**WEST SUSSEX COUNTY COUNCIL
STRATEGIC PLANNING CONSULTATION**

SUBJECT: P/76/16/PL - Construction of a building for the packaging, preparation & distribution of fresh foods with ancillary accommodation associated with the existing horticultural business, revisions to internal access road, car parking & hardstanding areas & landscaping & provision of a wetland. This application affects the setting of Listed Buildings.

LOCATION: Sefter Farm, Pagham Road, Bognor Regis, West Sussex, PO21 3PX.

This is the WSCC highways and transport response to the planning application.

| 1603        | P102        | 12    |      |

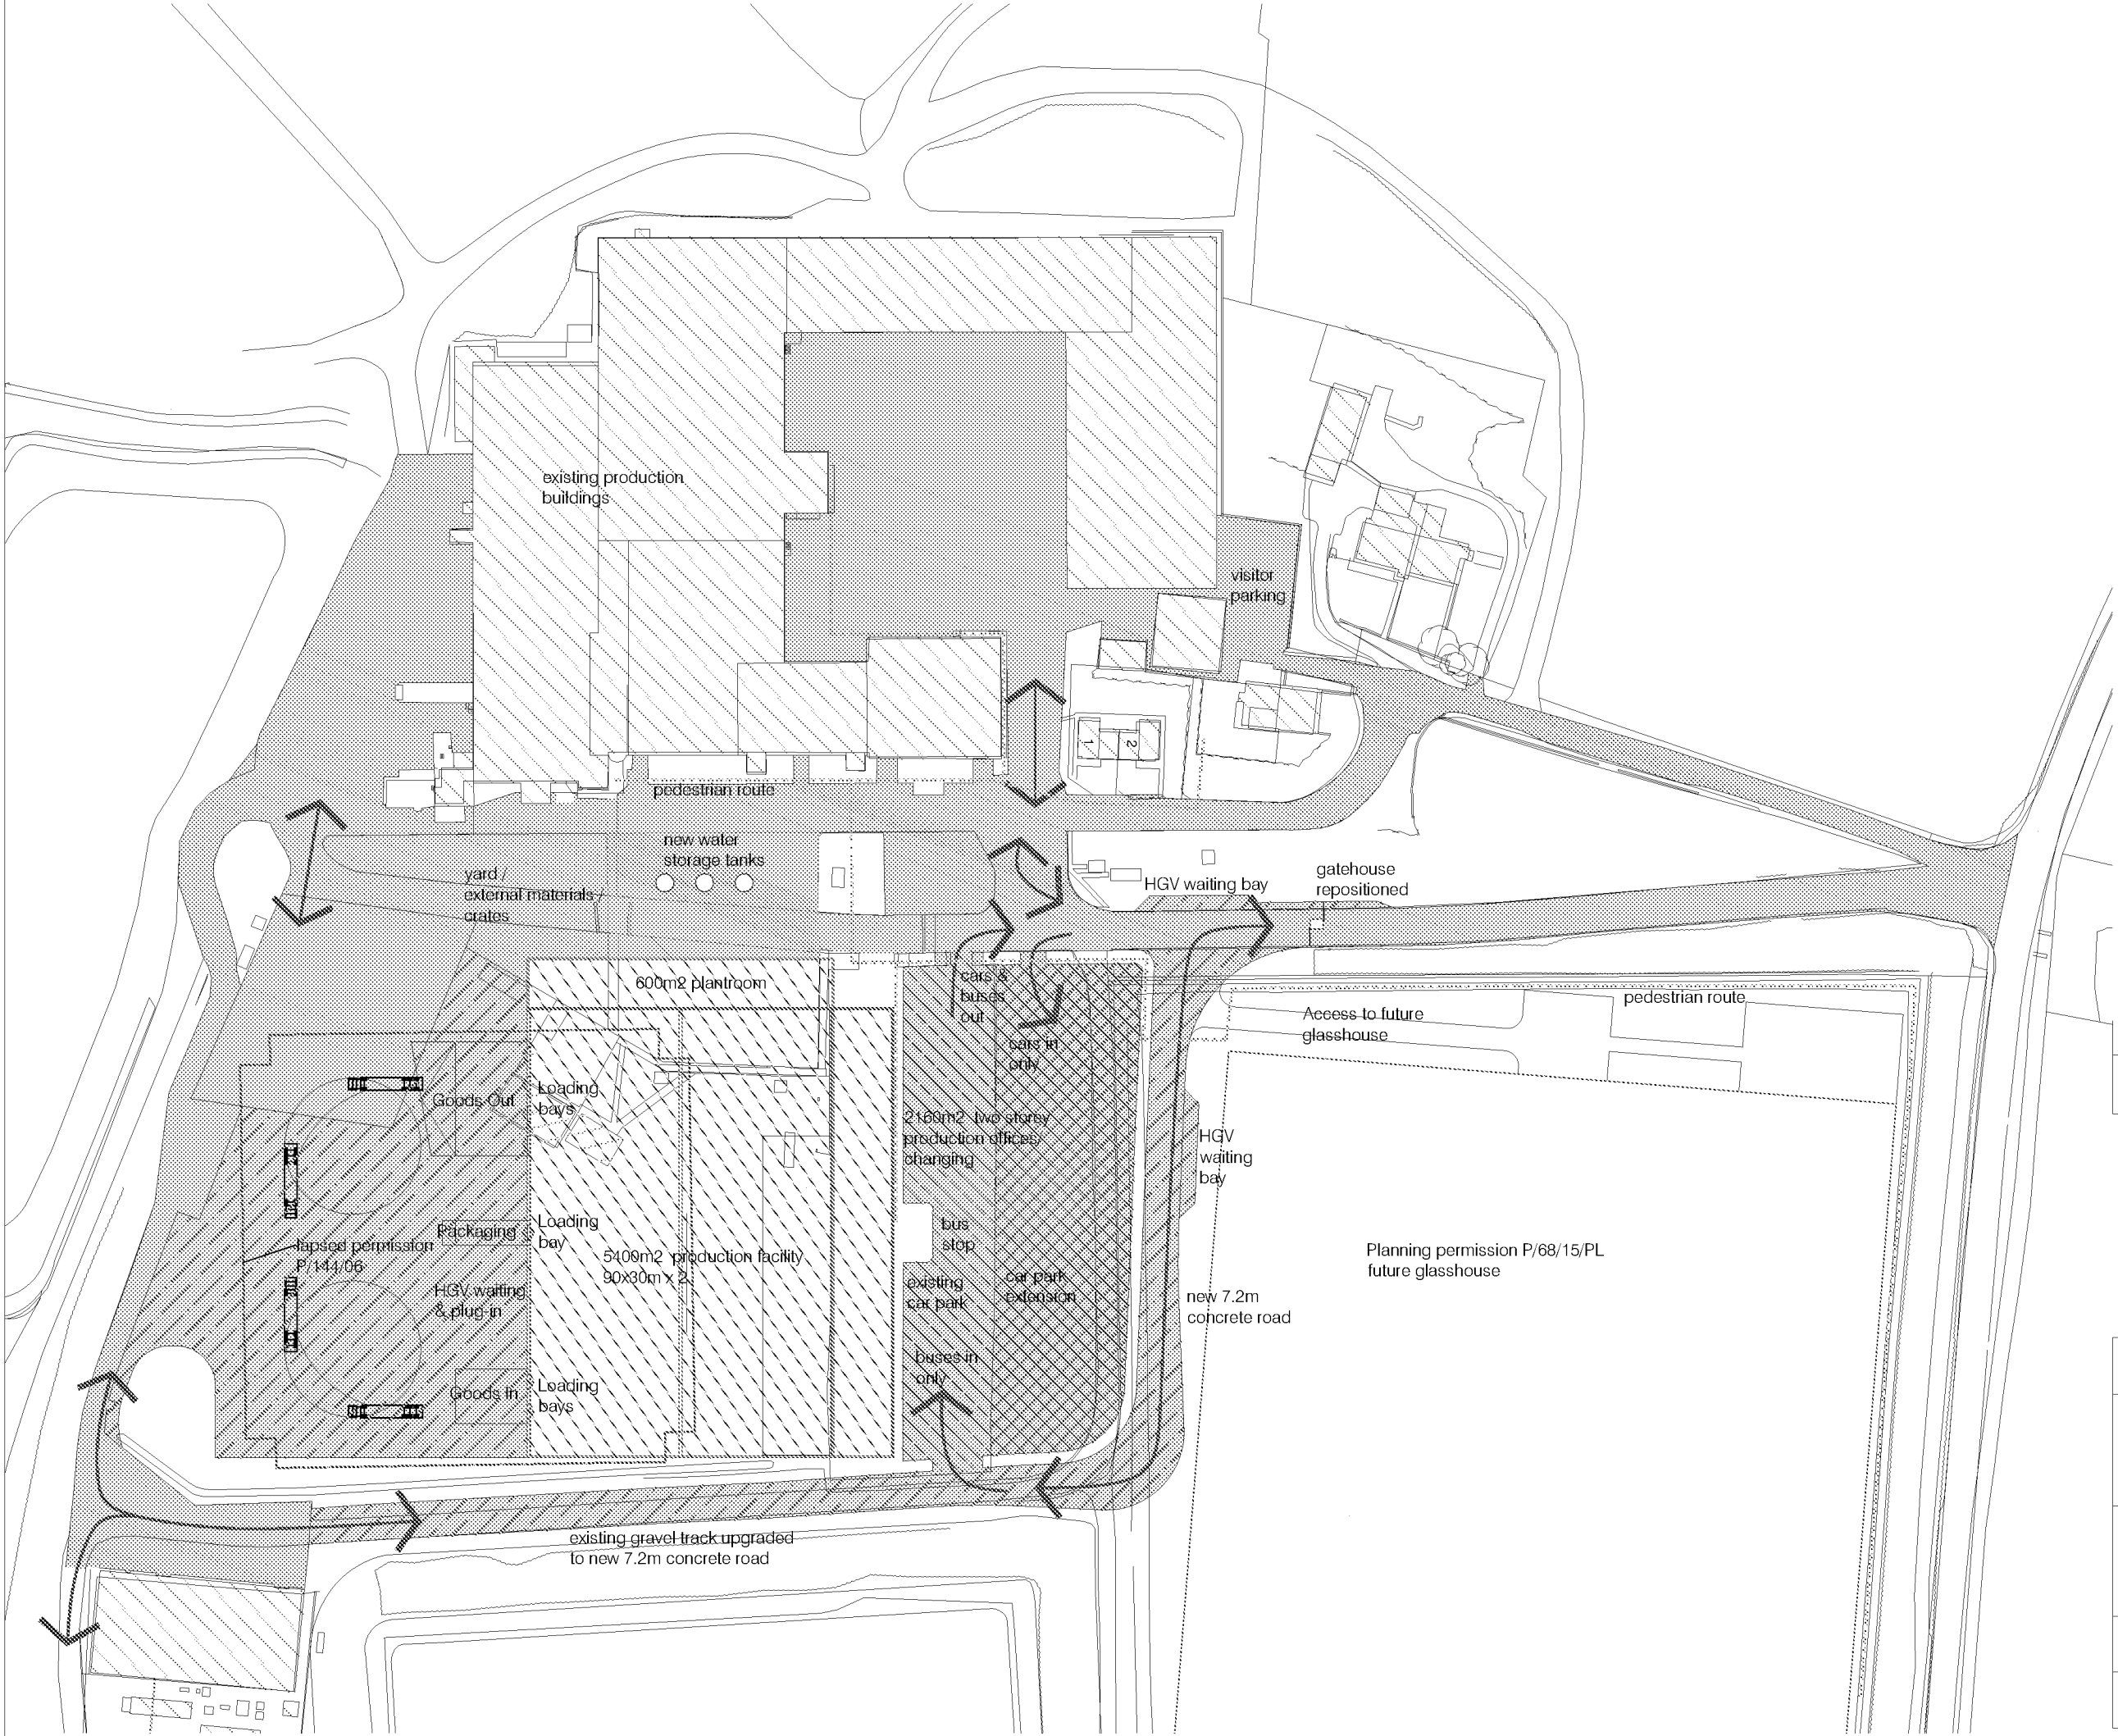
- Office facility – 1,857sqm (although 2,160sqm is quoted on Drg. No. P102 Rev. 12 provided by Curtis Leeves Technical Ltd.)
- Pack House – 5,887sqm (although 5,400sqm is quoted on Drg. No. P102 Rev. 12)
- **Total roof area of new buildings – 7,744sqm (7,560sqm if using the figures quoted from Drg. No. P102 Rev. 12)**

Both existing and proposed parking and turning for cars is shown in one location east of the new building. Parking and turning for HGVs and/or delivery vehicles is shown to the rear (west) of the building. Although the applicant states that the uses proposed are sui generis, if B1 (office) and B8 (storage and distribution) planning uses are used, the WSCC Parking Guidance document suggests that the number of spaces should be as follows:

- Office use (1 space per 40m² + 5% for disabled/mobility impaired drivers) – 46 (+2 of these for disabled/mobility impaired drivers) – based on 1,857sqm floor space (54 if floor area quoted on plan used)
- Pack House (B8 storage and distribution has been used at 1 space per 100sqm + 5% for disabled/mobility impaired drivers) – 58 (+1 of these for disabled/mobility impaired drivers) - based on 5,887sqm floor space (54 if using the floor area quoted on the plan used)

Total: 104 (108 if using floor areas quoted on plan)

From both on-site observation and scrutiny of 'Google Streetview', the existing car park currently provides about 130 car parking spaces and appears to be already well-used. However, spaces are not marked out and are on gravel (or similar). The applicant does provide a plan showing the location of the proposed building and the car parking moved eastwards. However, as spaces are again not marked out, no assessment can be made as to how many spaces will be available for use following redevelopment. The applicant states that the existing provision will be adequate for the new proposal although again, this needs to be qualified by the applicant. The floor area of the existing buildings (including those consented but not built yet) should be provided by the applicant to enable further consideration of parking requirements.
